## **M25 junction 28 improvement scheme**

**TR010029**

### **9.46 Applicant's comments on responses to London Borough of Havering D3a Response**

February 2021

**FIGURE 10 OVERVIEW OF ALL COLLISIONS FROM 2015 – 2019**

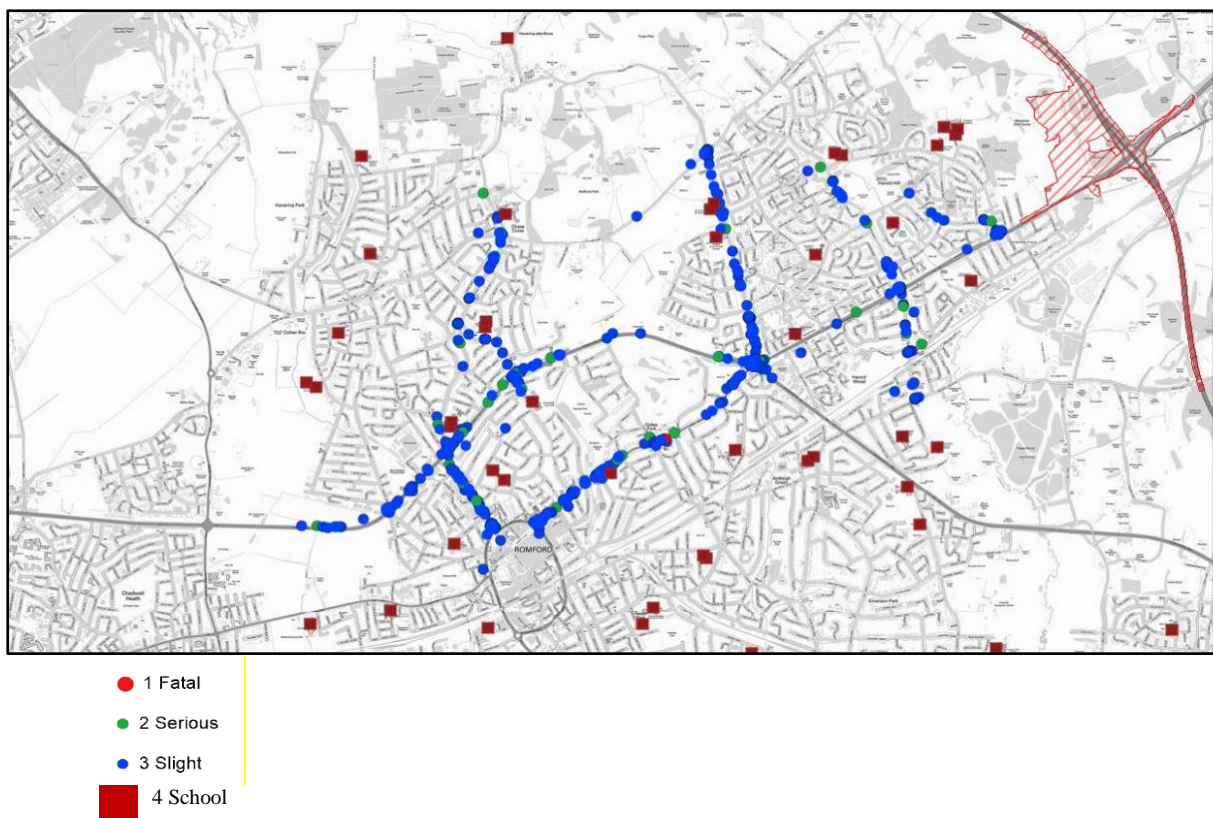
REP3A-042-5	<p>The collision data that is referred to in the Applicant's response to the question TA 1.5 is dated (2013 -2017) more up to date data on this matter can be found in the LBH Local Impact Report (LIR) Figure 10 Overview of all the Collisions 2015 – 2019 (page 22).</p>	<p>The 2013 to 2017 collision data used by Highways England for the assessment of the Scheme was the most recent data available when the assessment was undertaken.</p> <p>Figure 10 of the LBH's LIR (REP1-031) shows more up to date collision data covering the road network to the west of junction 28 managed by TfL and LBH. Highways England notes that the data in Figure 10 does not cover junction 28 itself. It is also noted that this data indicates relatively few collisions have been recorded on the A12 over the most recent five years on the A12 between junction 28 and Gallows Corner, and that most of these collisions have resulted in slight injuries, with only one serious injury. Highways England has no reason to believe that this data affects the conclusions reached in the Transport Assessment Report (APP-098) or the Transport Assessment Supplementary Information Report (PDB-003).</p>
